Subject: ADC Planning Application EP/49/20/HH - 45 The Ridings, East Preston, BN16 2TW

We have recently been made aware that yet another Planning Application has been made for the redevelopment of 45 The Ridings. Whilst this present Planning Application differs from its predecessors, in that it deals solely with the redevelopment of 45 The Ridings, and not the associated development of other properties on its land, many of the adverse comments made on the previous proposal by the East Preston Parish Council and others would appear to remain valid.

PROPOSED SECOND FLOOR PLAN

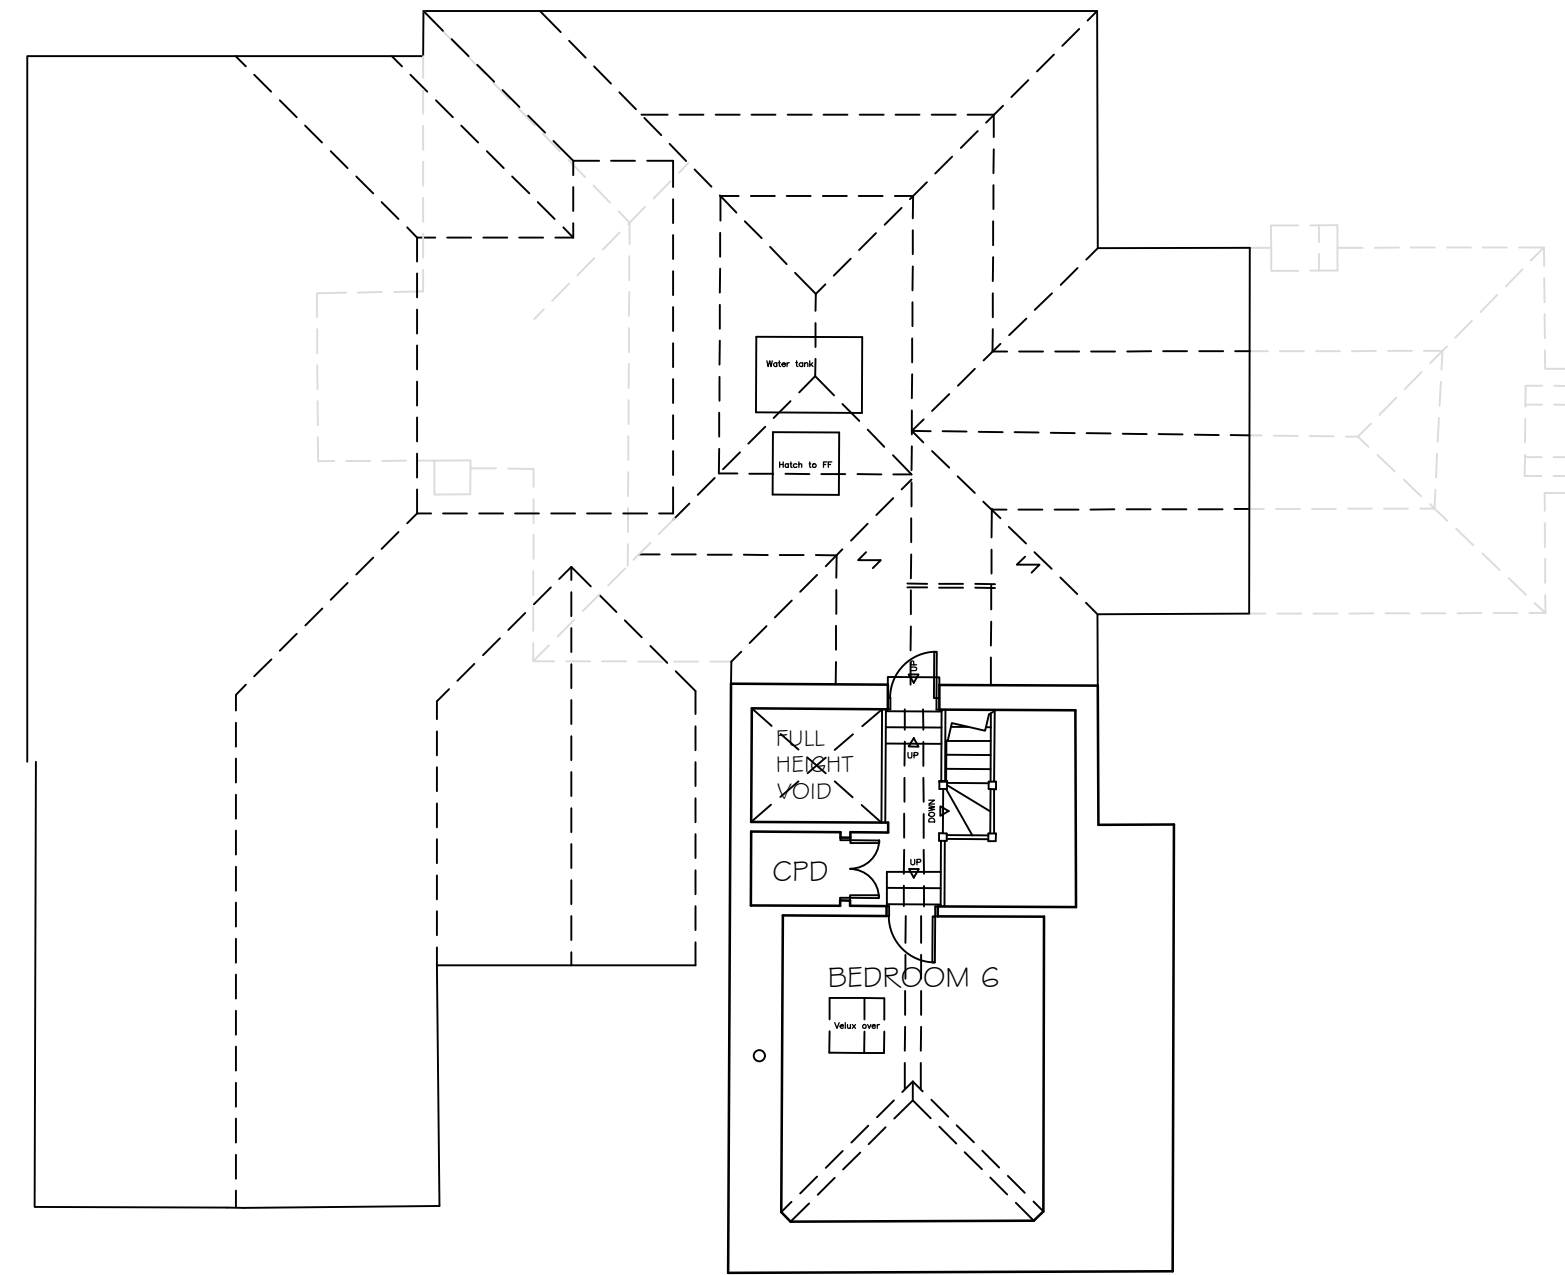
We note that this present Application is proposing to increase the number of bedrooms from 4 to 6 by building into the loft space, thus effectively turning the house into a 3-storey dwelling. The East Preston Village Design Statement (EPVDS) places many houses in The Ridings within a "Character Area and with Special Features" and it makes specific reference to houses numbered "all from 28 (even) and 41 (odd) upwards". The proposed redevelopment of No 45 lies within this area. The EPVDS makes the point that "any new development should not clash with its surroundings" and that "the relatively large gardens should be retained as they are a characteristic of the area". It is surprising therefore, that no mention is made in the Application for any change to the design of parking areas at the house - 6 bedrooms implies a greater car parking need than 4.
